Markup Summary

dskendall (3)

4830 PLATINUM DRIVE VACATION PLAT

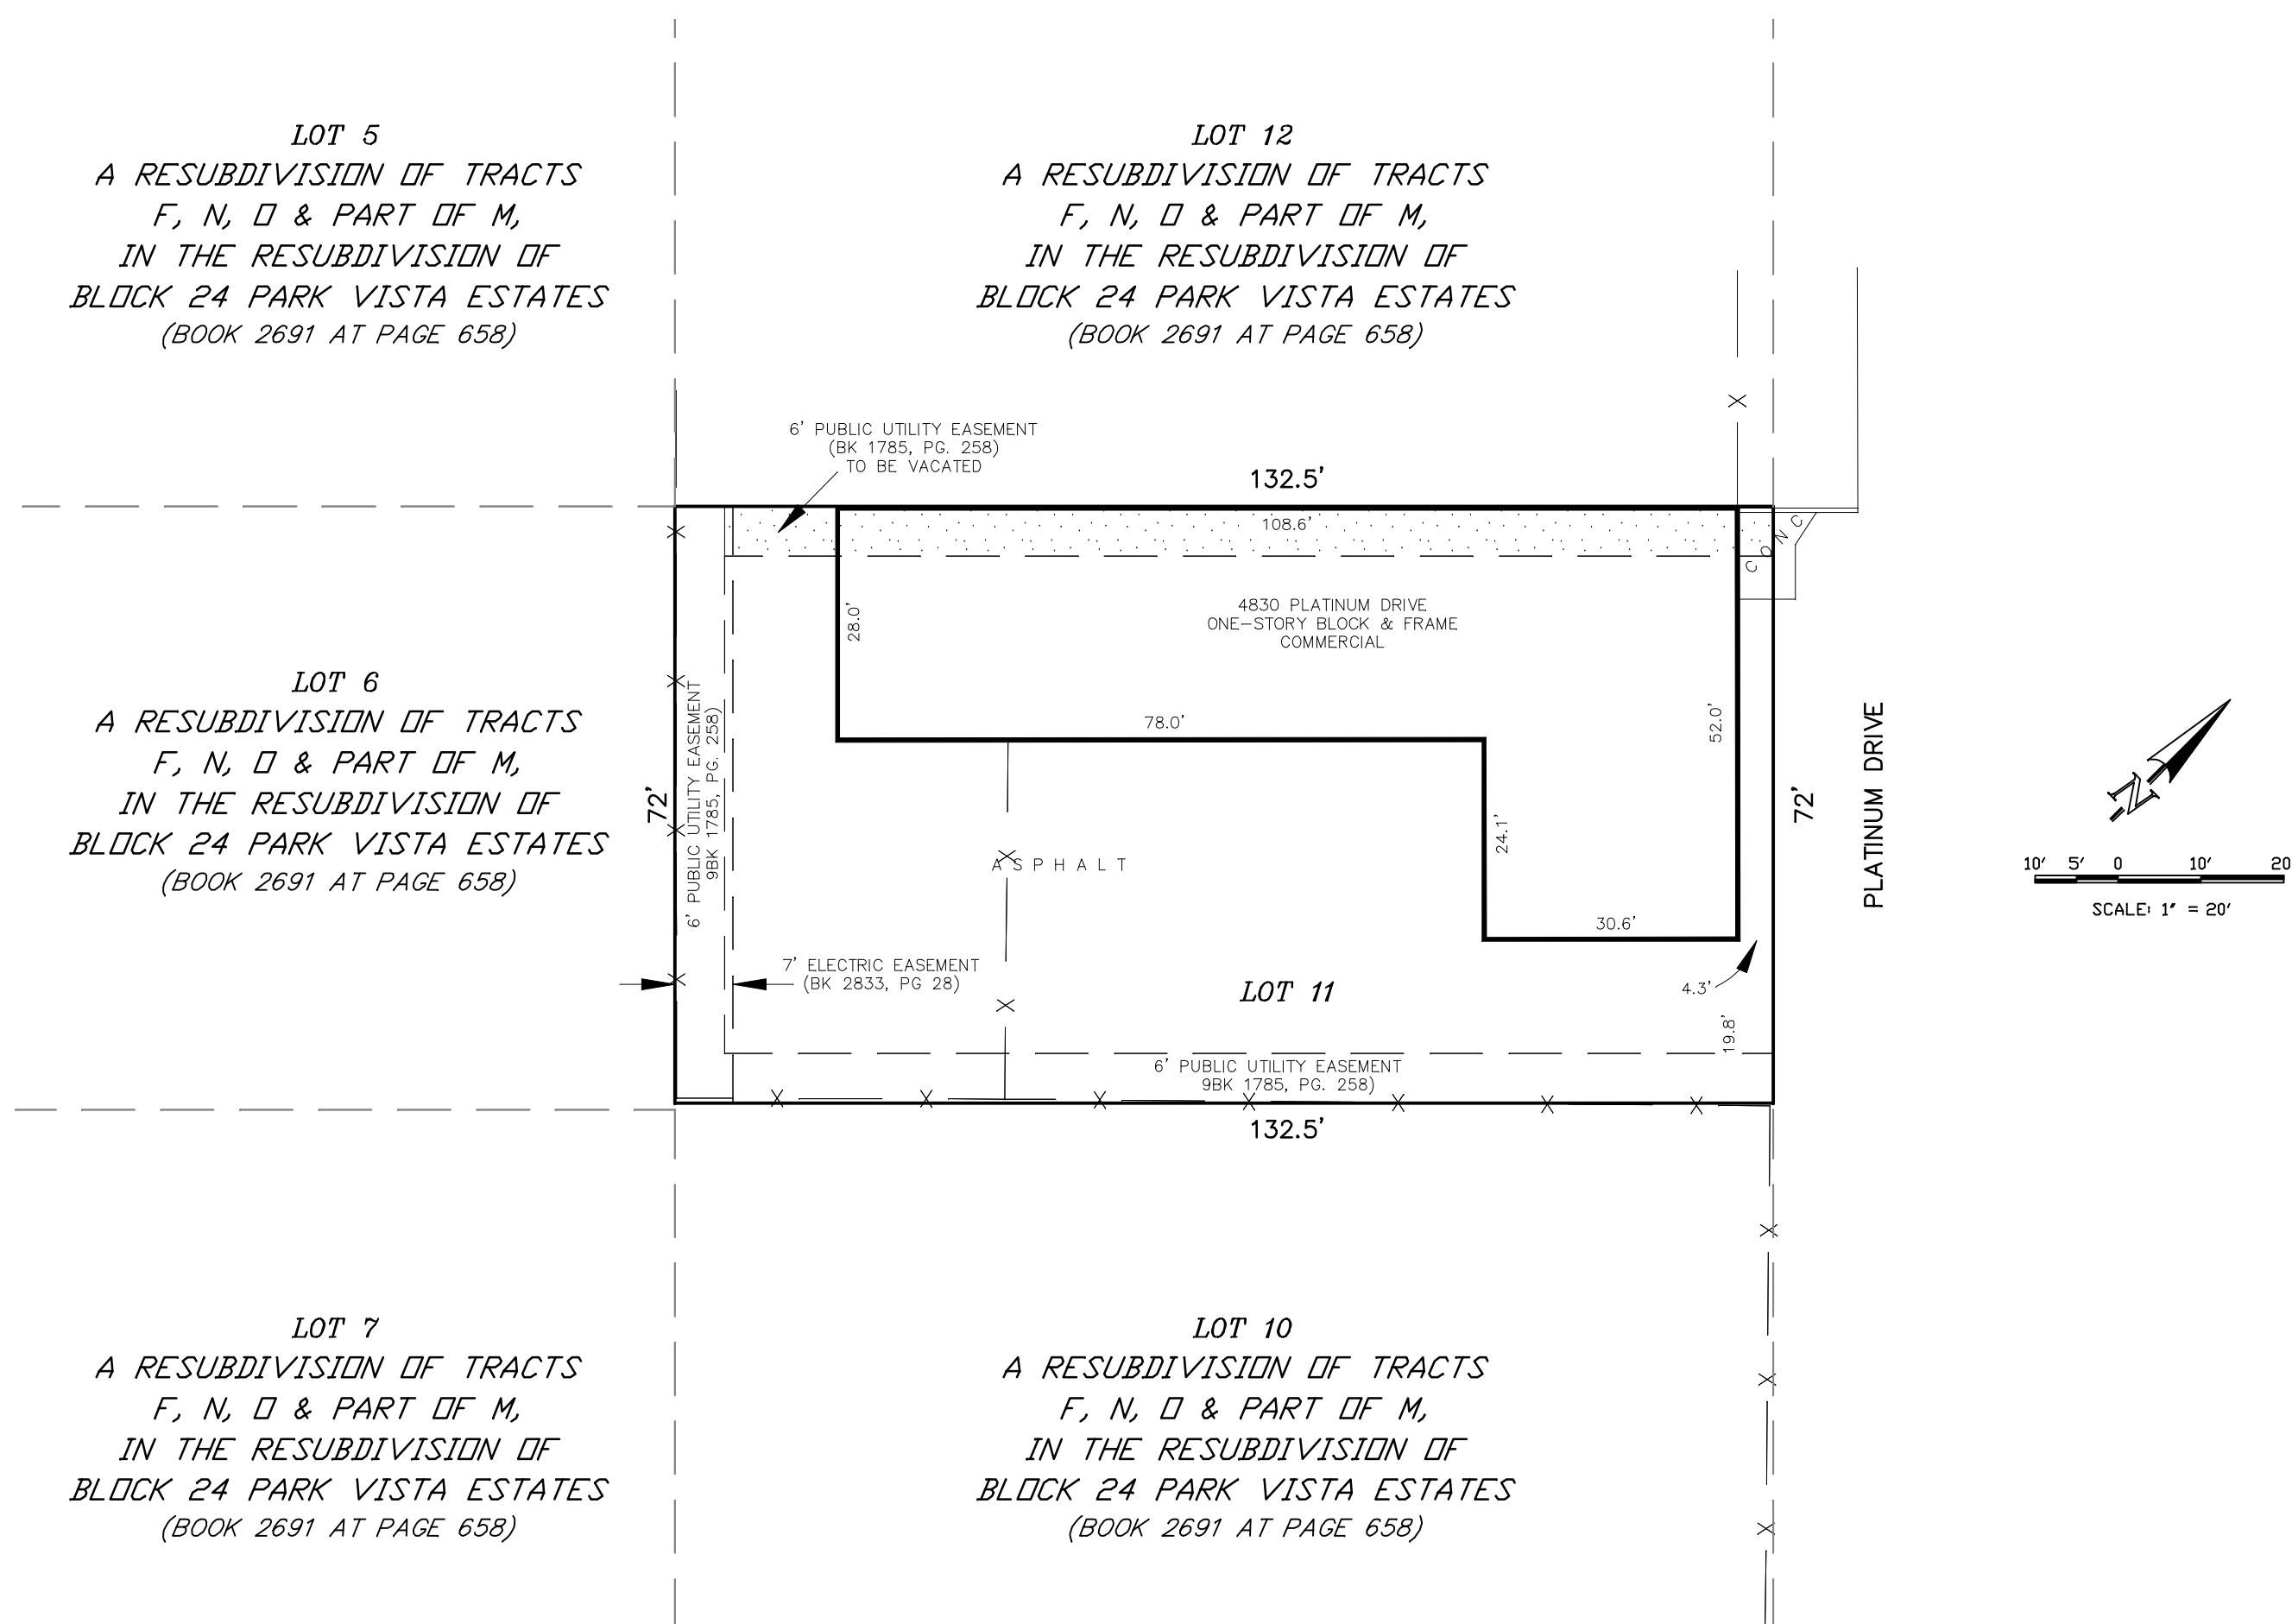
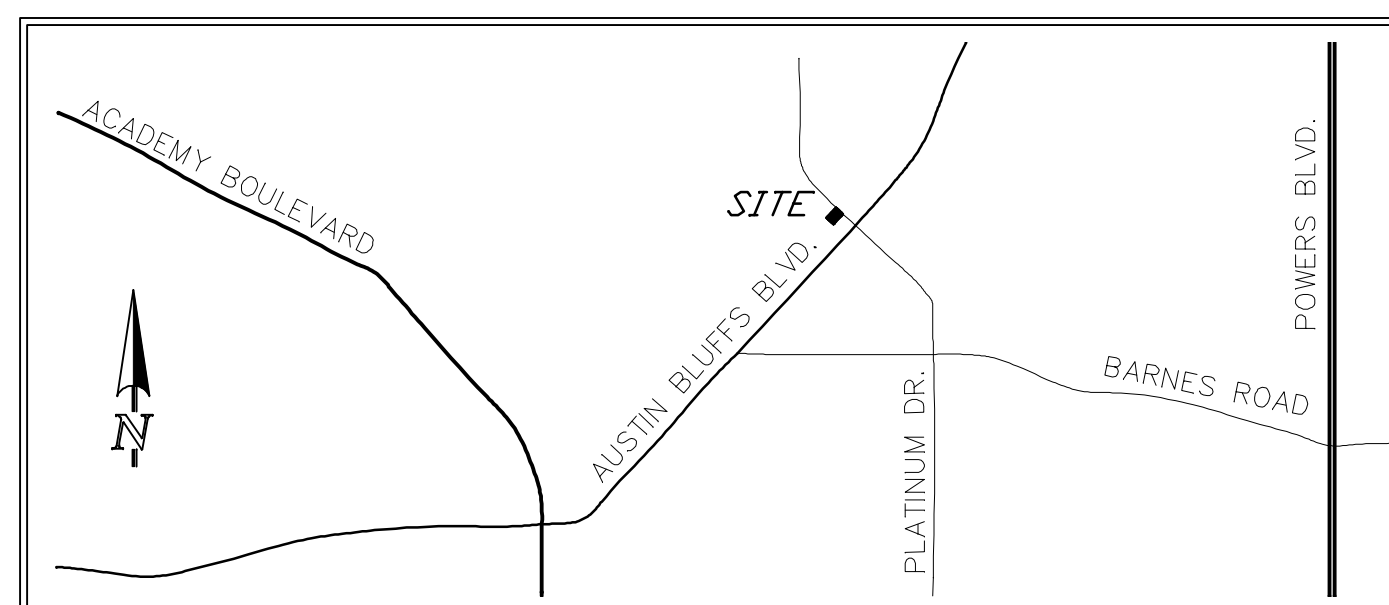
I believe North is in this direction.

The scan of this drawing is not good enough, resubmit with a better scan.
